Date 26 February 2024
Our Ref 24/00194/CLP

Town and Country Planning Act 1990 (As Amended)
18 Eastcroft Road, West Ewell, Surrey
Proposed Use: Formation of vehicular access incorporating a dropped kerb to access existing hardstanding driveway

Thank you for your planning application which was received on 21 February 2024. We have checked the application and have found that it is invalid. This means that we cannot currently accept it for registration. The following details must therefore be submitted for the application to be registered:

Location Plan

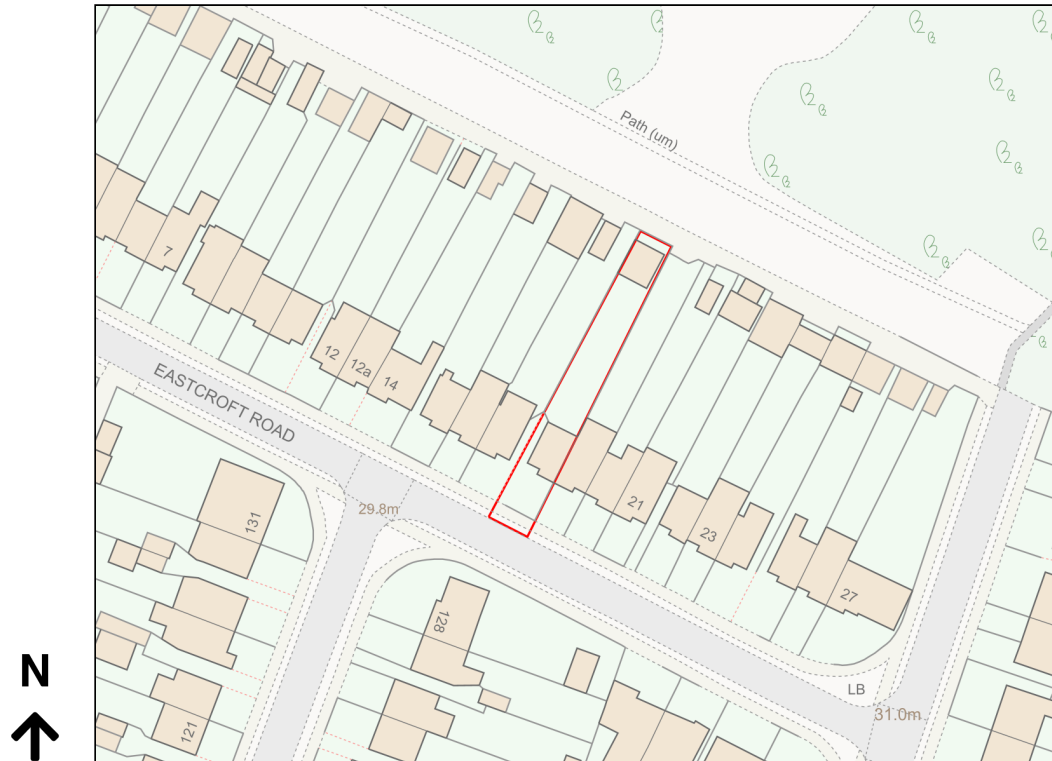
1 The application requires the submission of a location plan, usually at a scale of 1:1250, which must identify sufficient roads and/or buildings on land adjoining the application site, to ensure that the exact location of the application site is clear. The application site should be edged clearly with a red line on the location plan and should include all land necessary to carry out the proposed development which includes land required for access to the site from a public highway. As the proposal involves the creation of a new cross over, this needs to be included within the red line of the location plan. The plan should also show the direction of North. In summary, please outline the application site with a continuous red line and extend the red line up to the highway but including the pavement. There is no need to extend the red line the length of Eastcroft Road and beyond.
